# KITTITAS COUNTY COMMUNITY DEVELOPMENT SERVICES

Subject: Rucker Boundary Line Adjustment (BL-15-00005)

BOUNDARY LINE ADJUSTMENT
 PREPARED FOR
 MANORD RUCKER
 A PORTION OF THE SOUTHEAST QUARTER OF SECTION 30,
 TOWNSHIP 20 NORTH, RANGE 17 EAST, W.M.
 KITTITAS COUNTY WASHINGTON

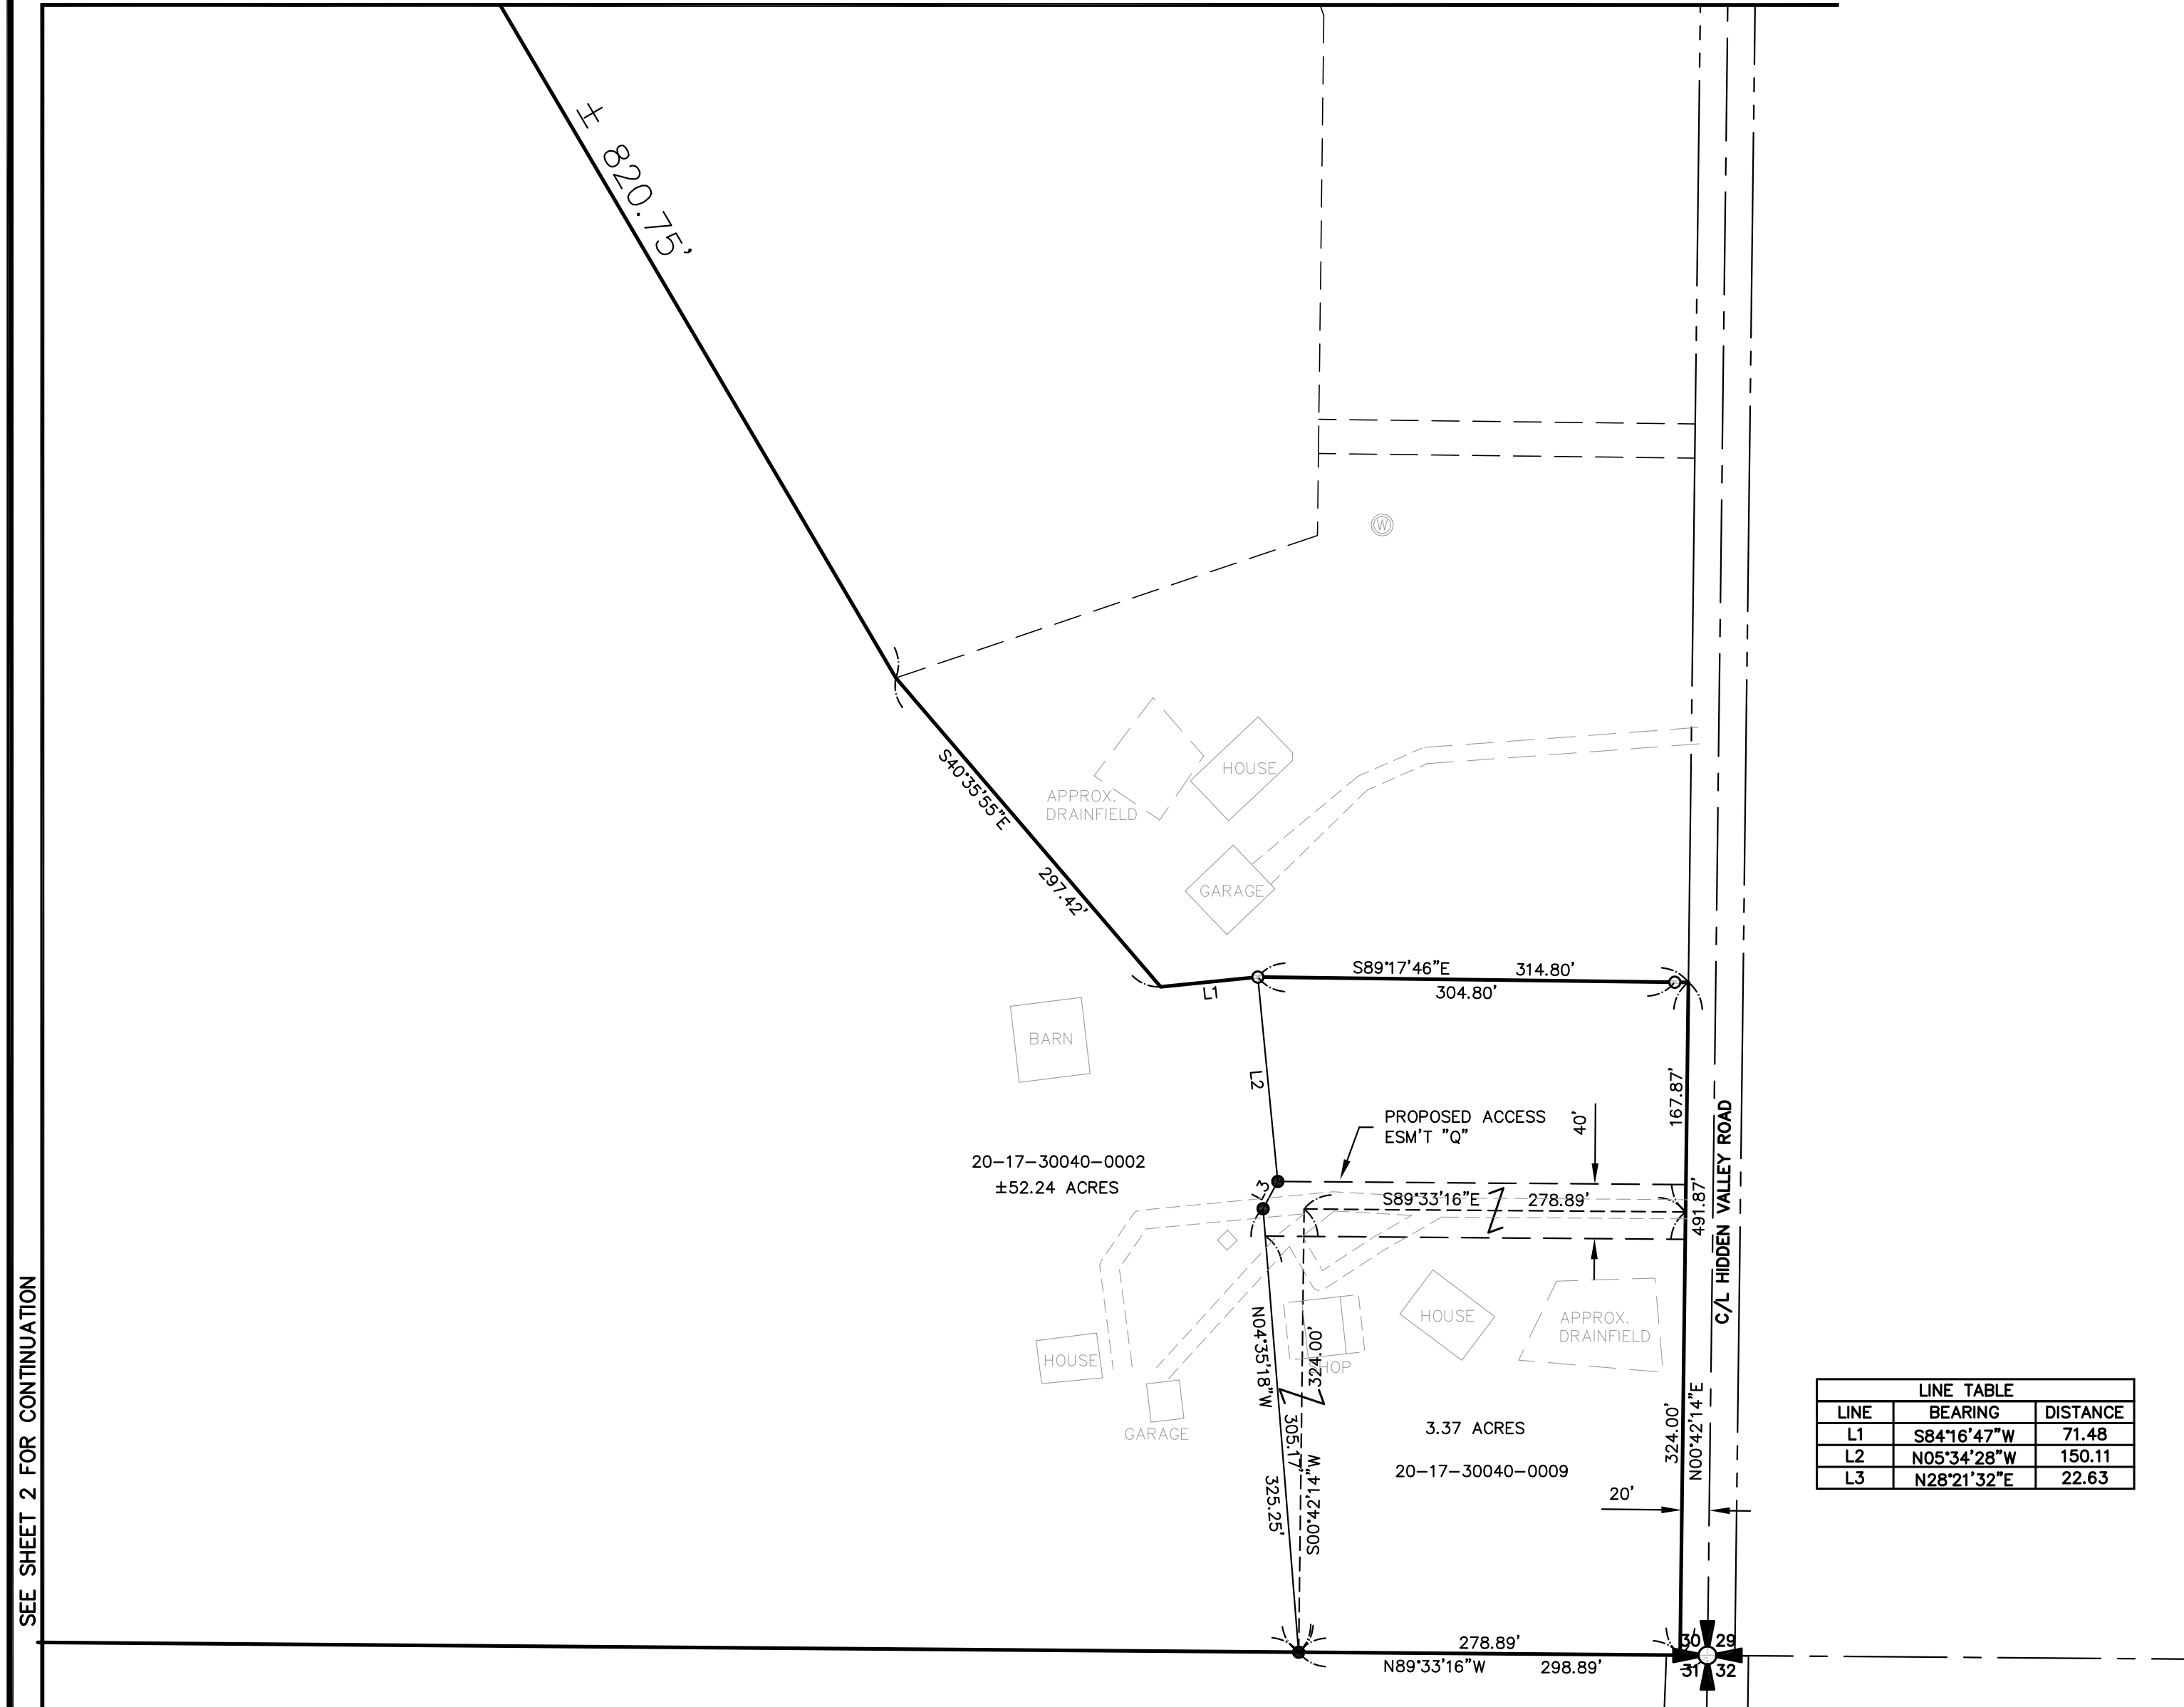
- ***Public Health will need measurements from the drainfield to the new property line and the location of the well serving the water system. For further questions regarding this additional information please contact Kittitas County Public Health 509-962-7515.***
